Ref 2022/0426 Planning Application and 2022/0559 Advertisement Consent Application

Proposal: Alterations to the shop front

Proposal: Installation of various shopfront advertisements including illuminated lettering on fascia sign, projecting signs, digital screen and window vinyl's

Address: Unit MSU4 The Glass Works, Barnsley, S70 1GW

| ISS                              | Revision | DATE        | Drm | Appr     |
|----------------------------------|----------|-------------|-----|----------|
| TYPICAL DETAILS<br>BUS STOP SIGN |          |             |     |          |

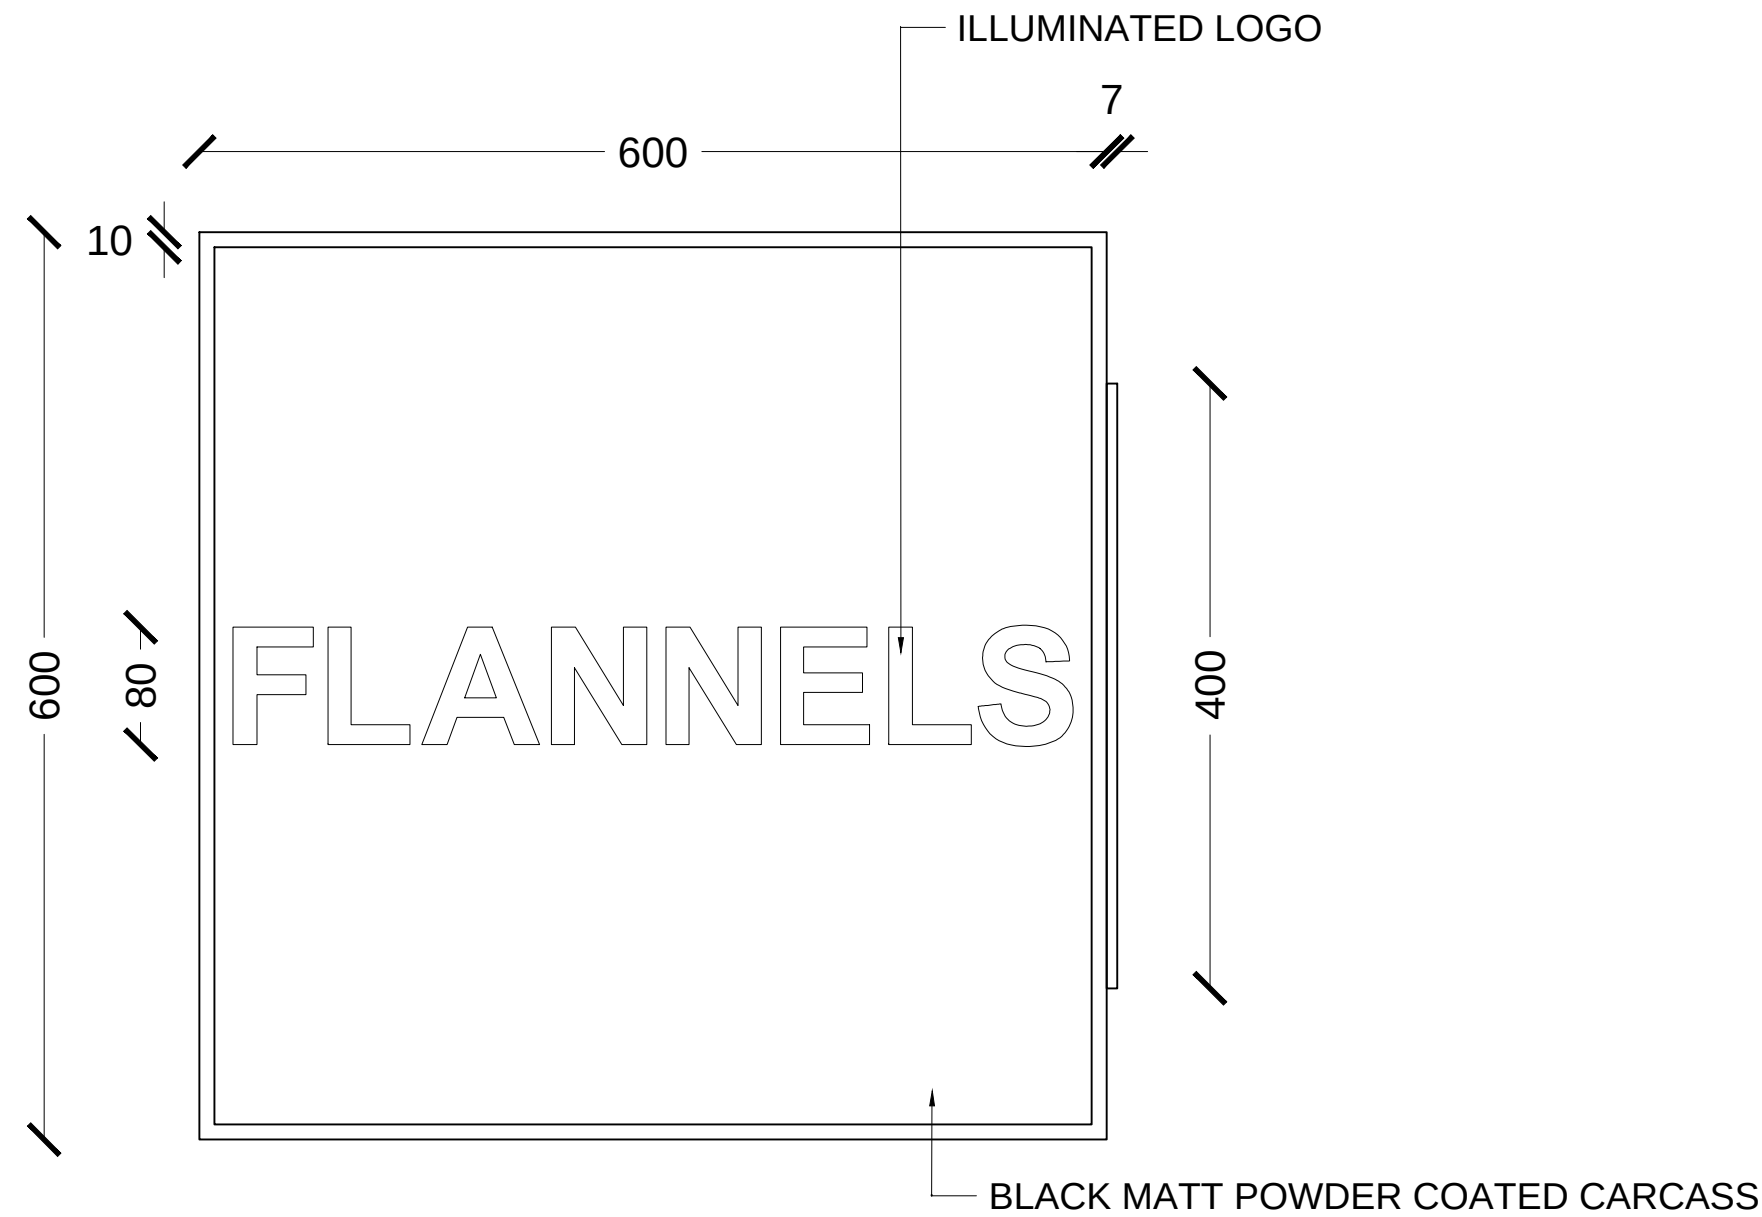
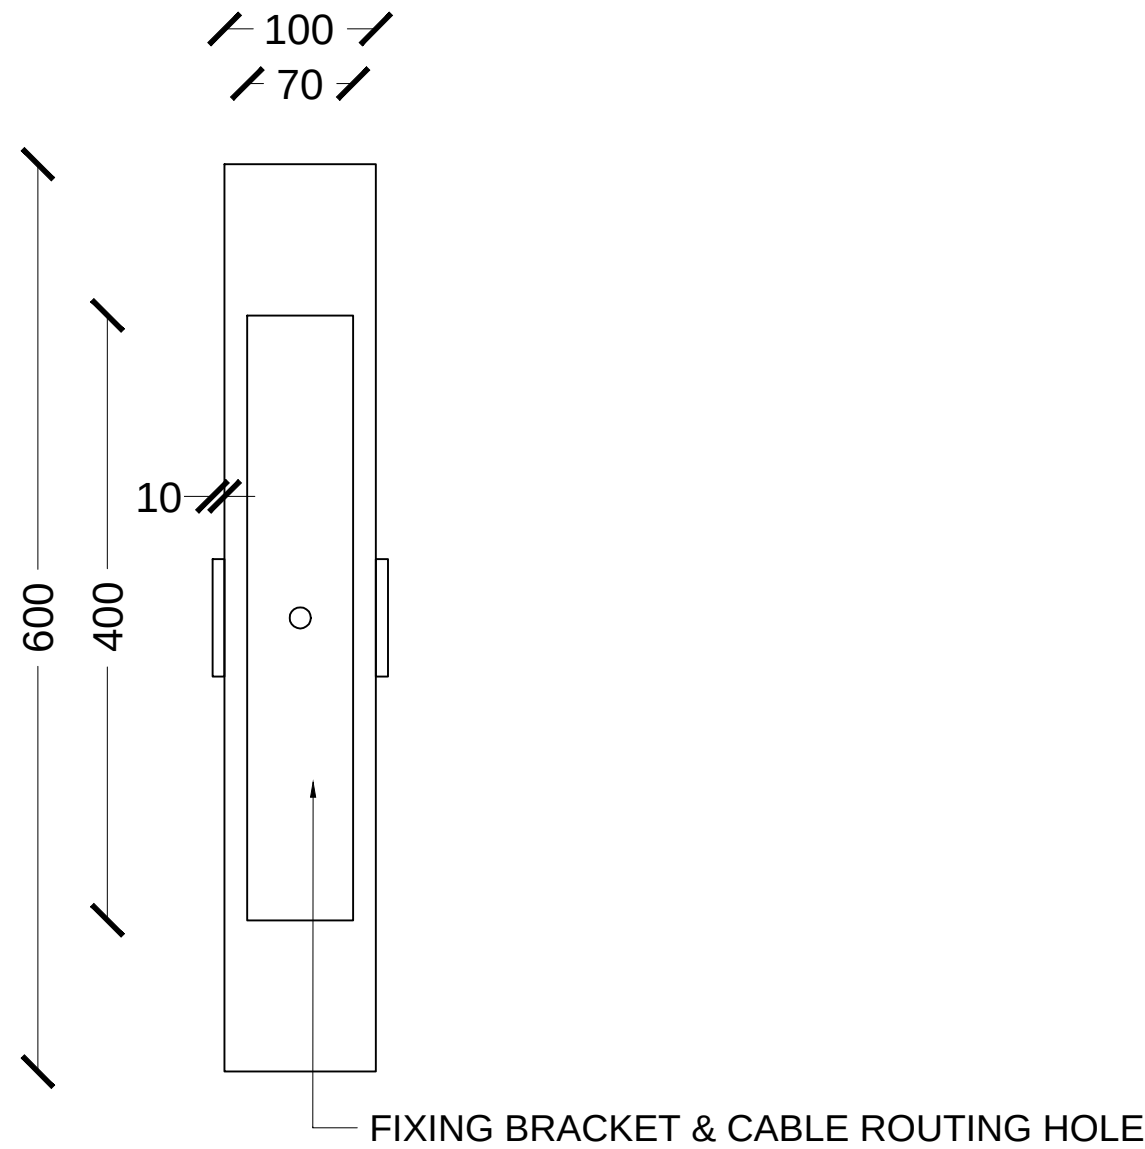
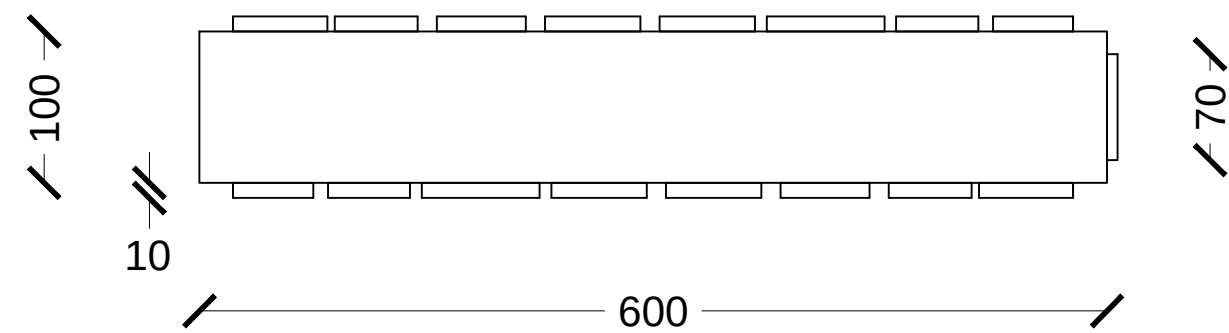
- No objections to removing the existing doors but require consistent approach to the existing shopfront finish/colour and object to new colour finish on the existing shopfront pillars.
- Concerns expressed about the proposed CCTV camera.
- Require clarity on the proposed bus stop and fascia signs and object to more than one fascia sign
- Object to the size of the proposed digital screen
- Object to the proposed vinyls including those with 'Flannels' lettering.

Following adverse comments to the proposed advertisements from the Design Officer, the application has been partially amended. The size of the projecting/bus stop signs has been clarified. The applicant has sought to justify the proposal for two fascia signs and the size of the digital screen based on the size (length) of the shop front (it is two units conjoined), has submitted that the vinyls are discrete and do not over dominate the frontage. The Design officer has agreed that as implemented the signage is acceptable.
